INTER-OFFICE MEMO

RE: Project #2022-007219/SI-2022-01478 and VA-2022-00235,
Site Plan-EPC Major Amendment and Variance-EPC
Wyoming Apartments- Titan

Note: Staff reviewed the DFT version of the Site Plan-EPC against the EPC version of the Site Plan-EPC, which is the standard, required review.

**12 GATE HINGE SECTION**  
SCALE: 3" = 1'-0"

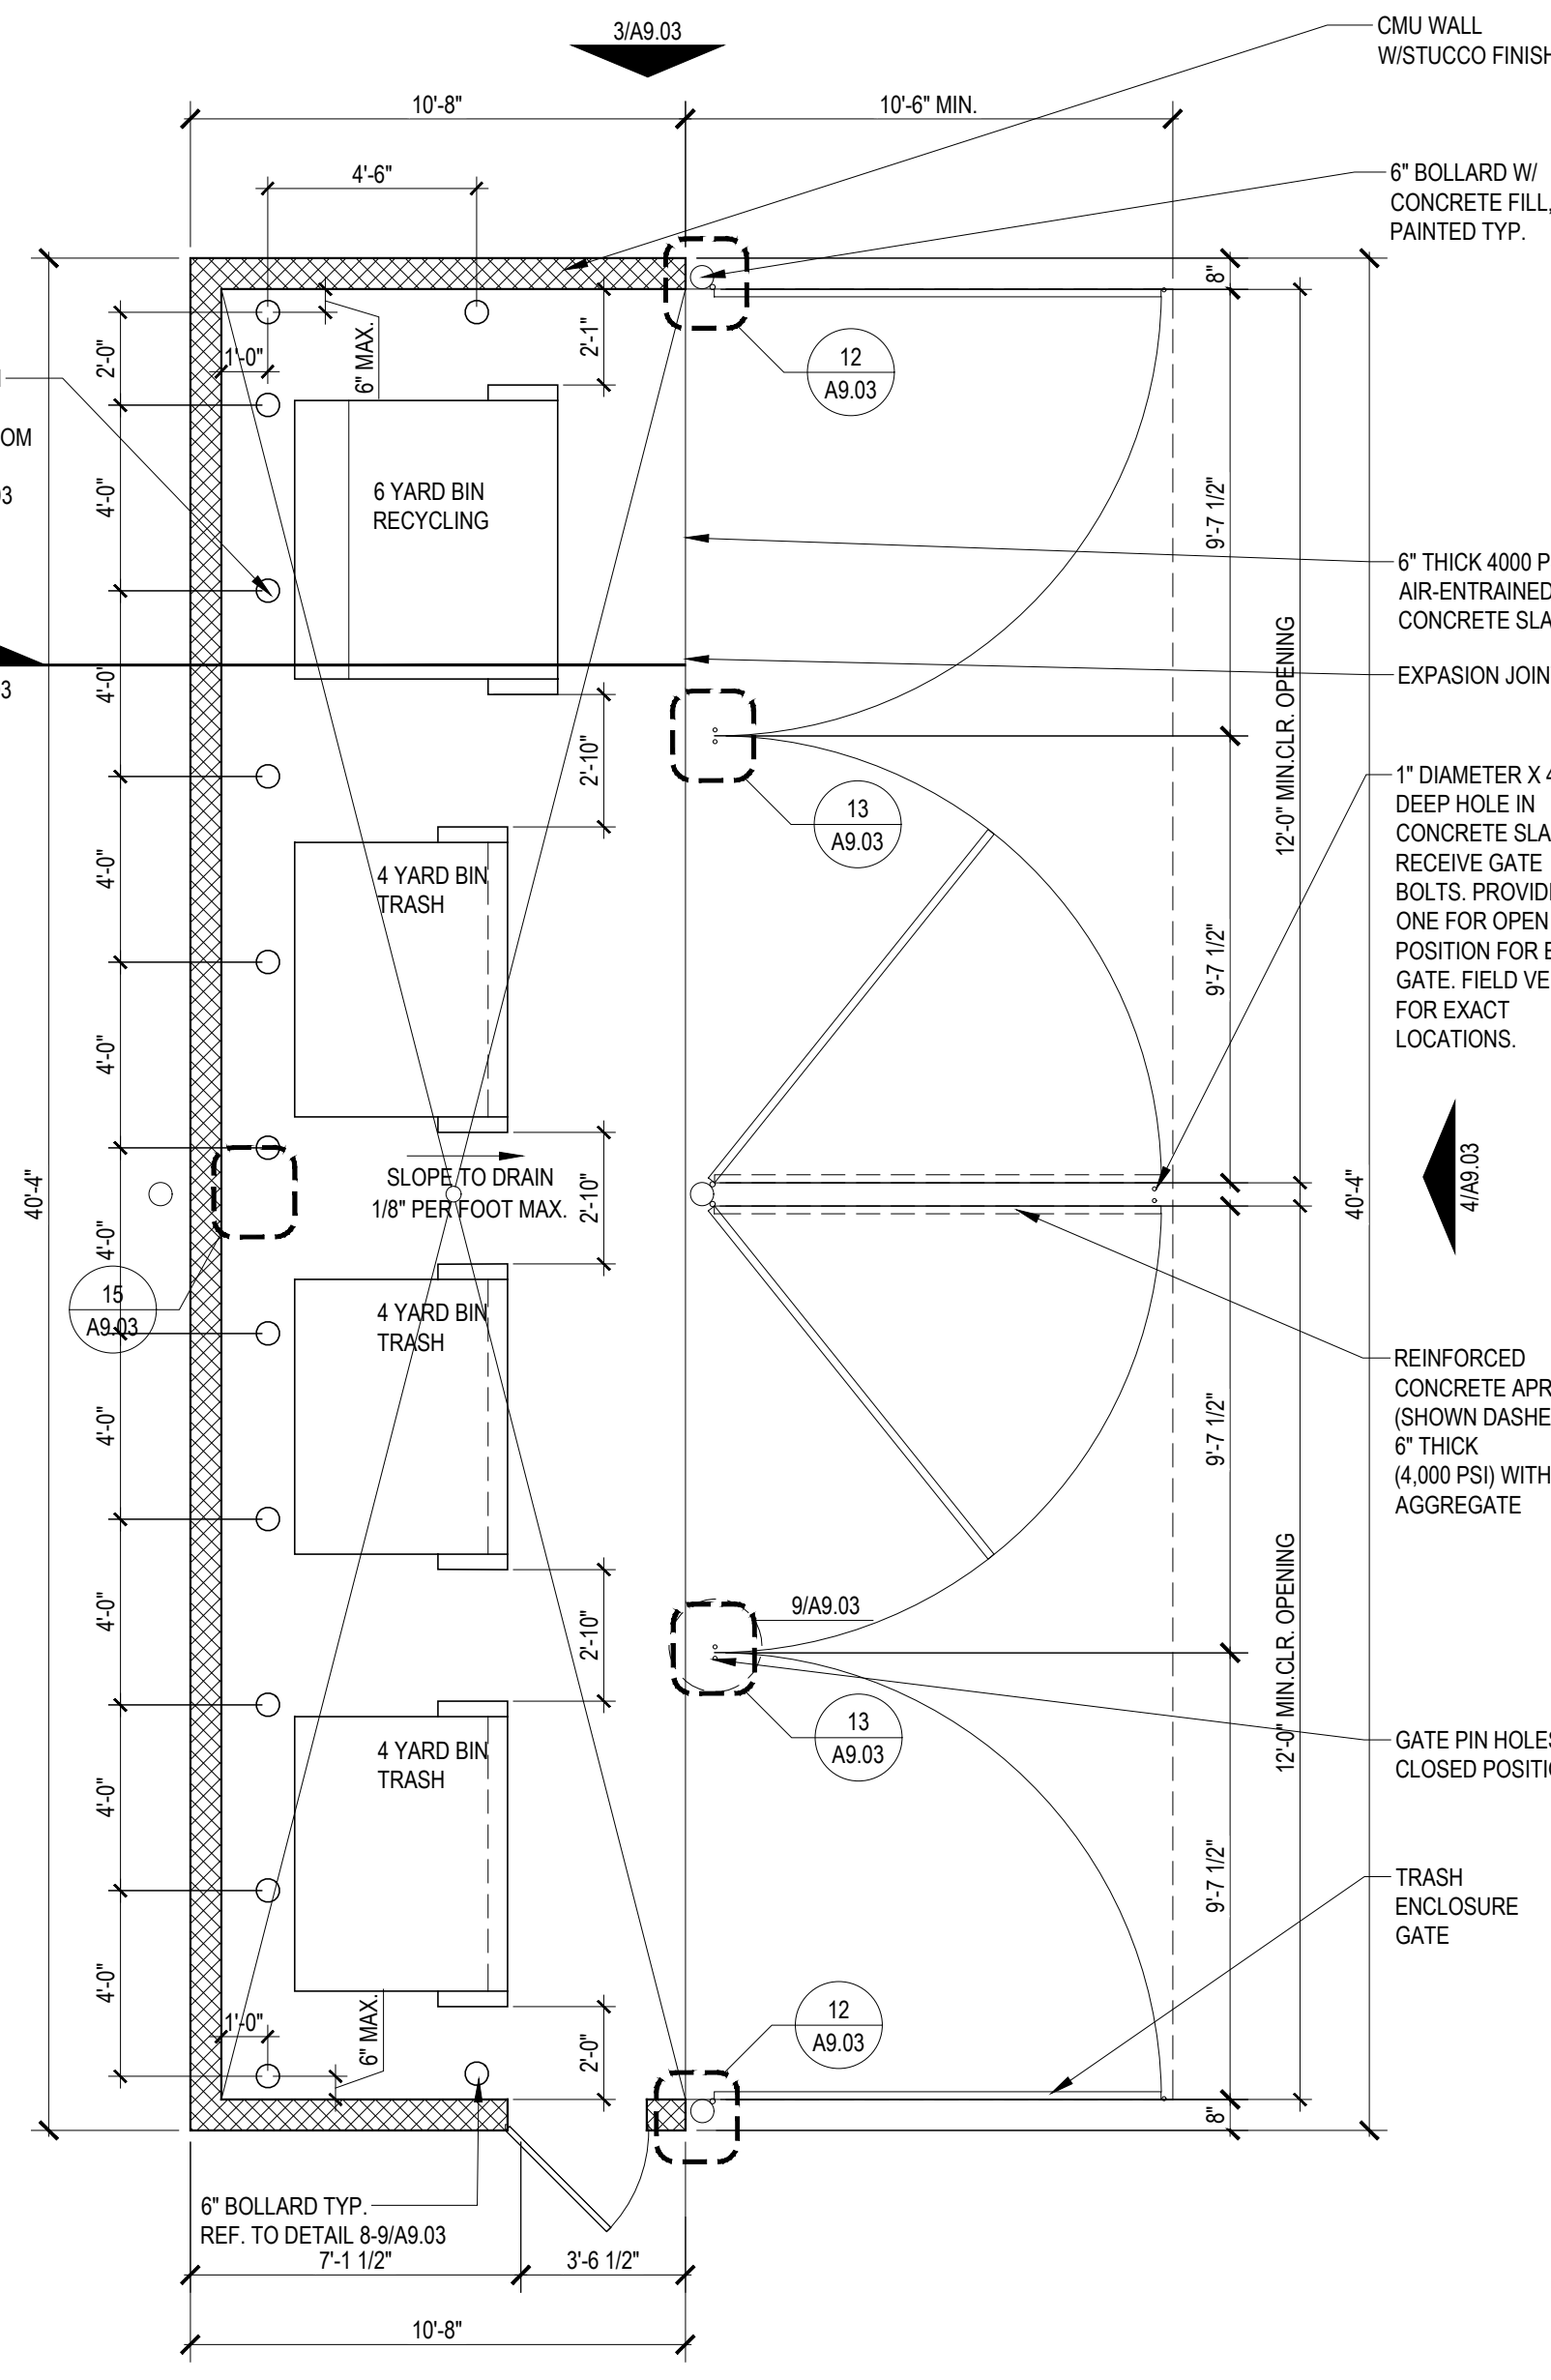
3. Condition 5: Same as Condition 4C: the keyed notes referred to in the memo, for pedestrian access, appear to be incorrect.
4. Condition 6- refuse enclosure: The EPC site plan set did not contain detail sheets (it should have) as part of the EPC review. The refuse enclosure detail in the DRF set does not indicate color of the block, stucco, or color and material of the gates.
